**Application by Alternative Use Boston Projects Limited for Boston Alternative Energy Facility**

**The Examining Authority's written questions and requests for information (ExQ1)**

**Issued on 14 October 2021**

TITLE
**GENERAL LAYOUT DRAWING PLAN
FIGURE 5.1 - SHEET 1 OF 2**

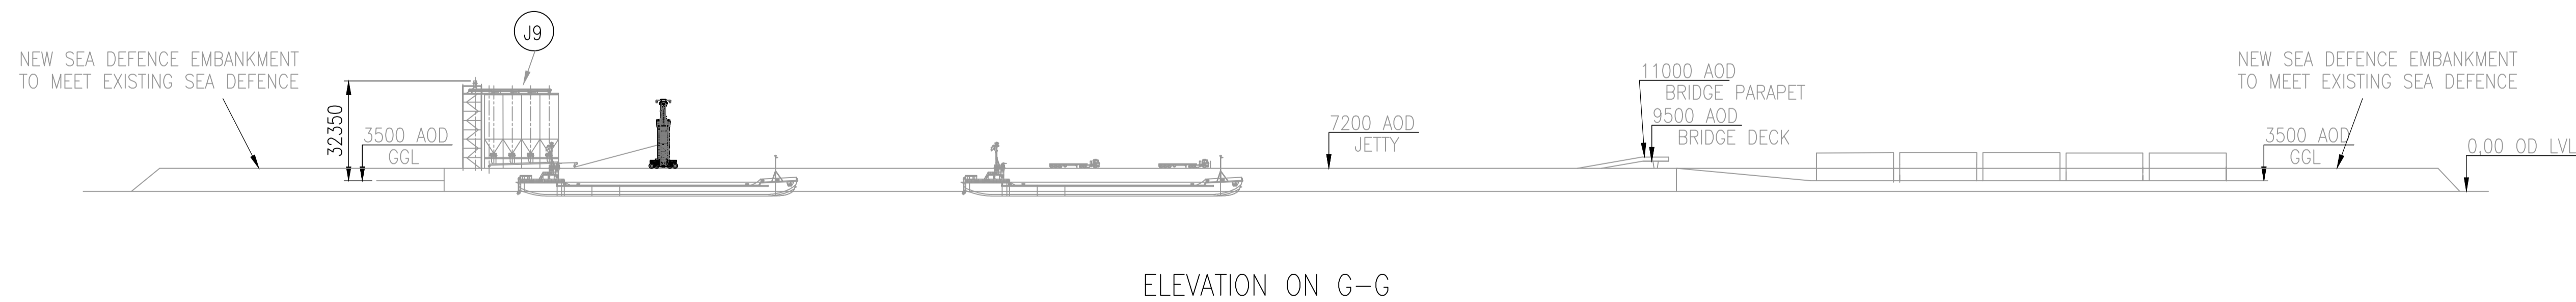
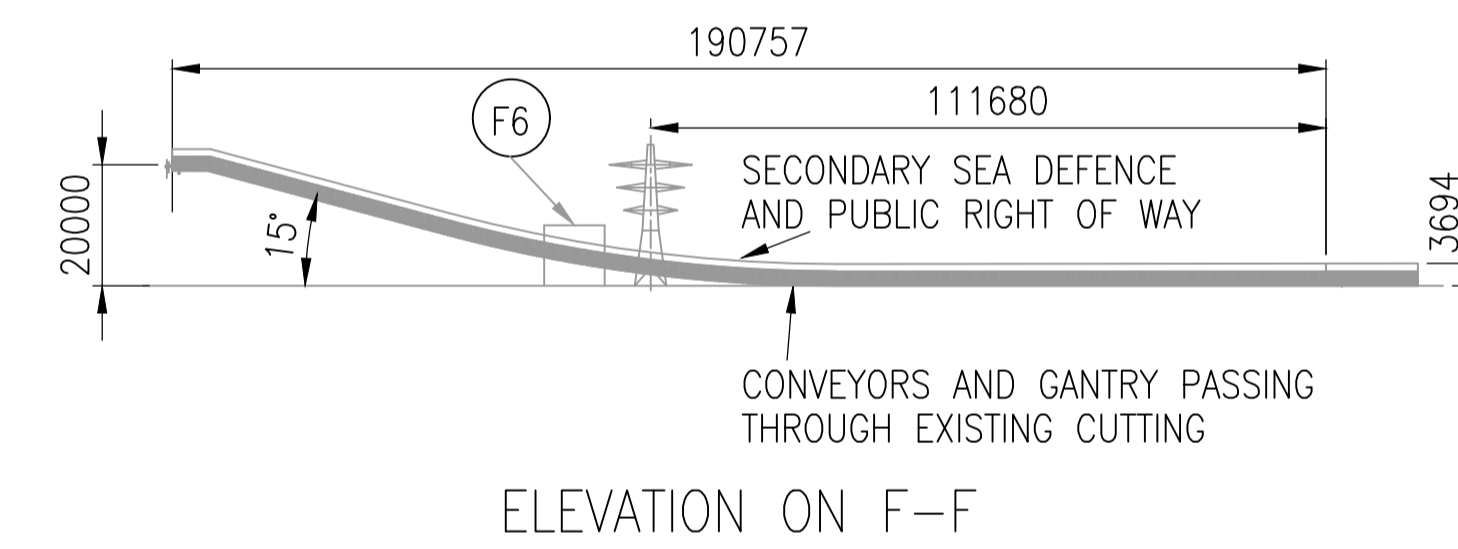
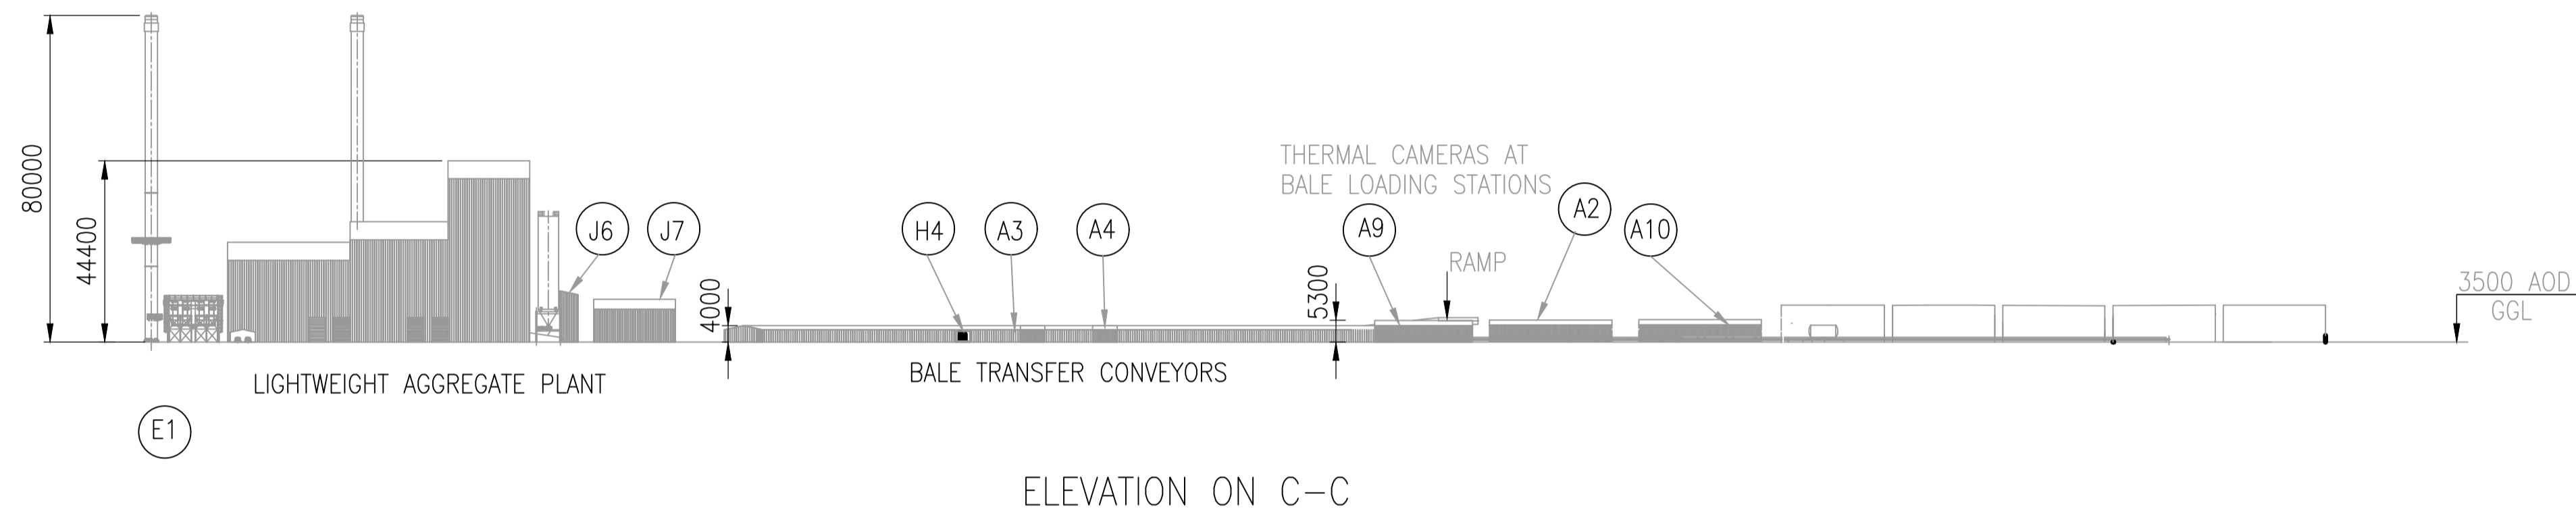
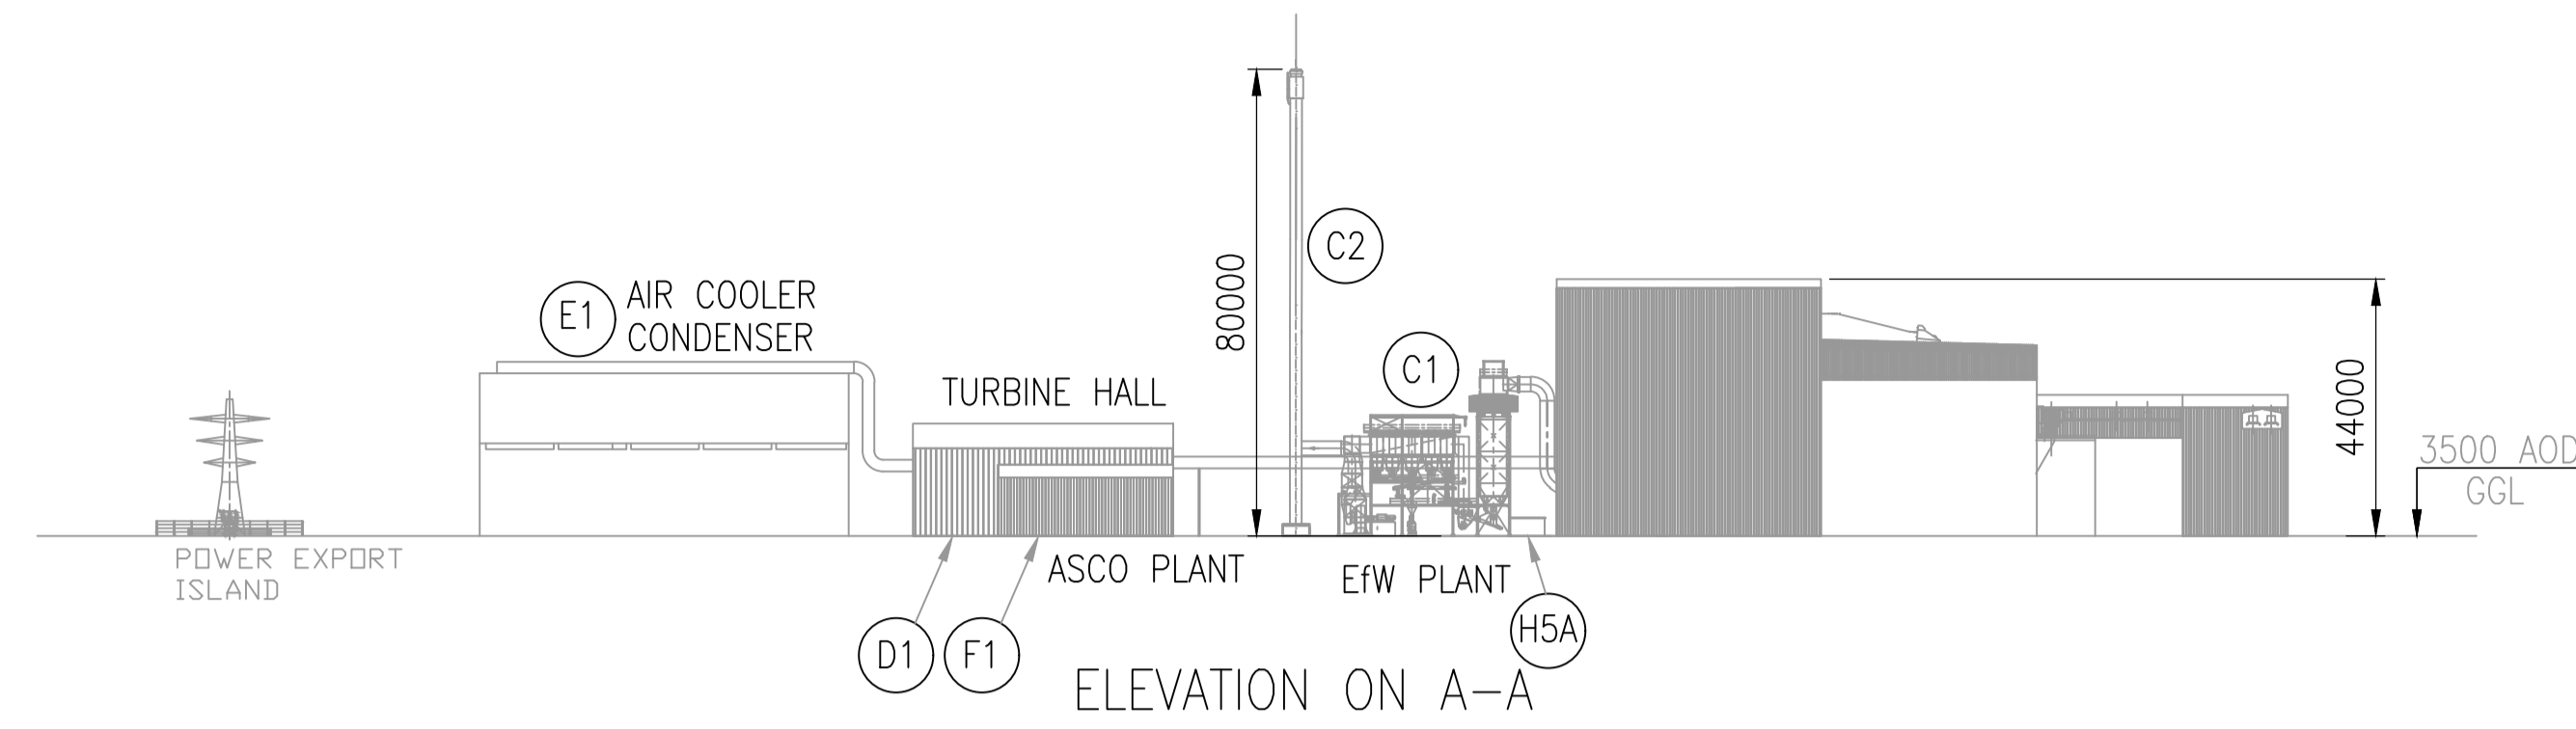
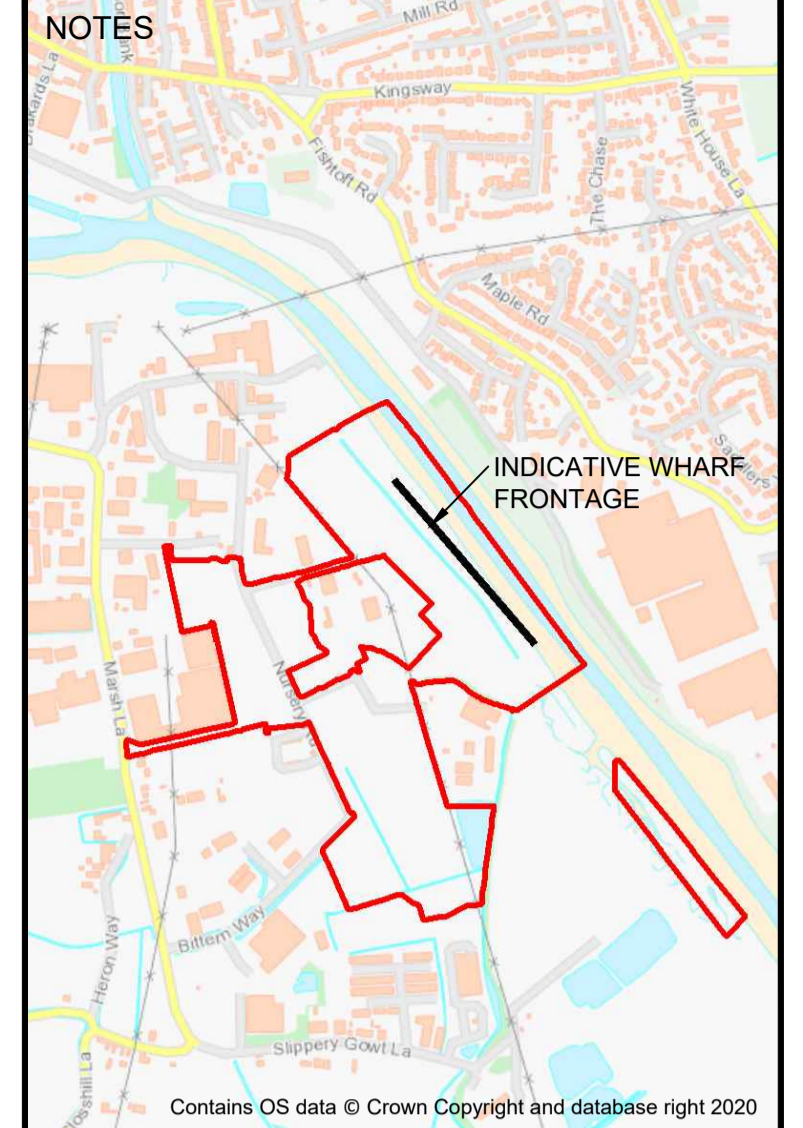
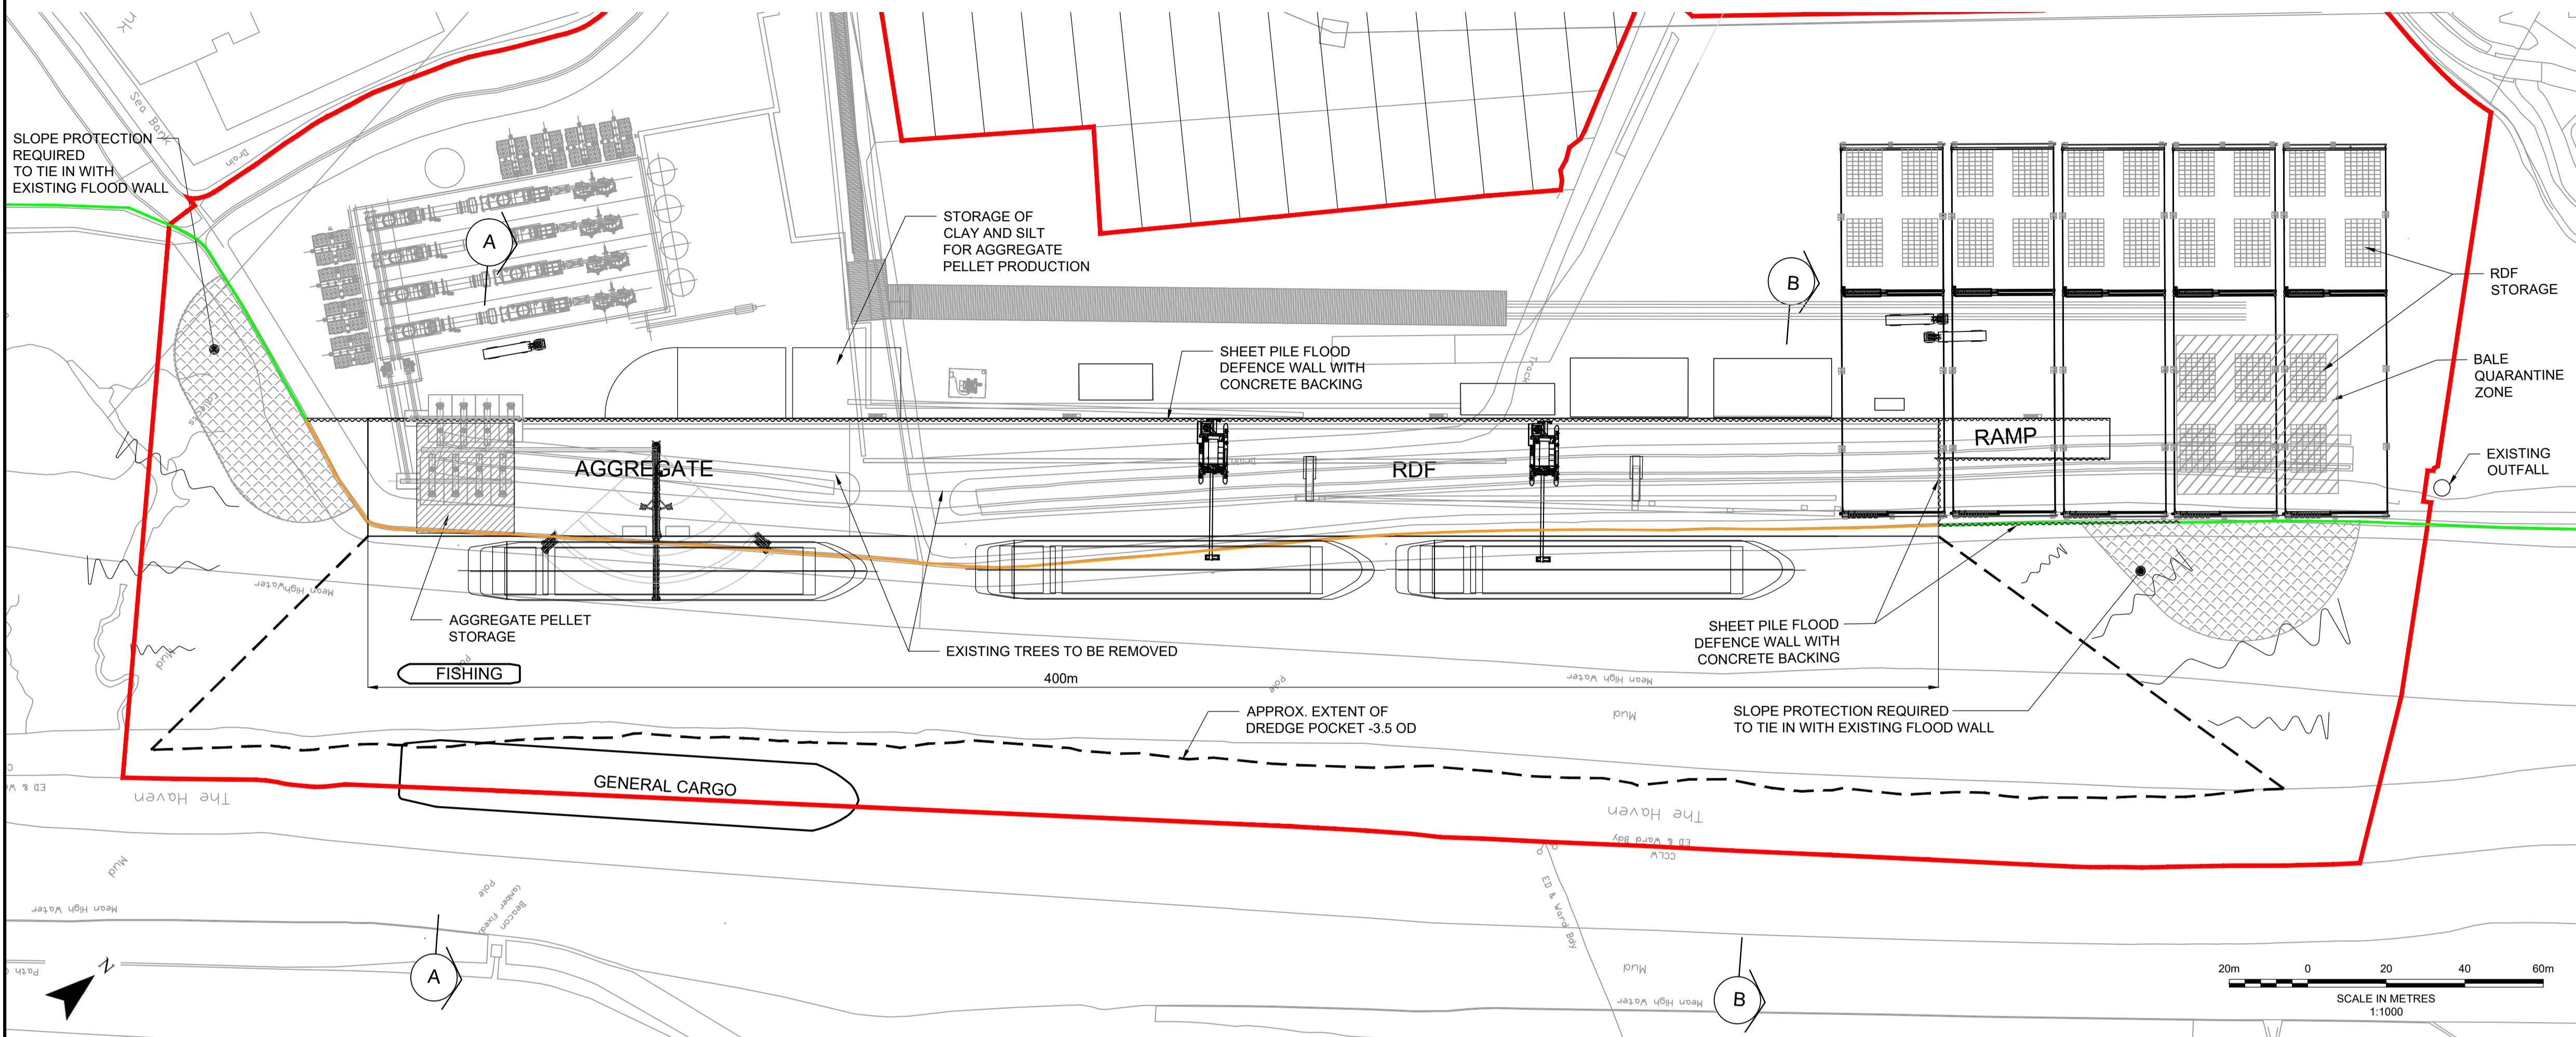
Q3.0.8	The Applicant	ES Chapter 5 paragraph 5.6.28 states that a quarantine area would be provided in the damaged bale store for any detected prohibited waste or bales found to be hot. However, a 'bale quarantine zone' and a 'damaged bale store' are shown in separate locations on ES Figure 5.1 (General Layout Drawing Plan). Please can the Applicant confirm the location of these elements.
Q3.0.9	The Applicant	<p>I note that the Environment Agency (EA) state, in their RR, that they are unlikely to be in a position to provide any assurance before the end of the Examination on whether they can grant a permit for the Proposed Development. Please can the Applicant provide an update on progress with each of the Environmental Permit (EP) applications referenced in the ES. Please could it also confirm whether the applications include a bespoke application for the discharge of surface water during construction, as suggested in ES Chapter 5.</p> <p>If the Applicant considers that any of the EPs are not required, please detail what alternative form of protection are proposed to satisfy the EA's concerns.</p>
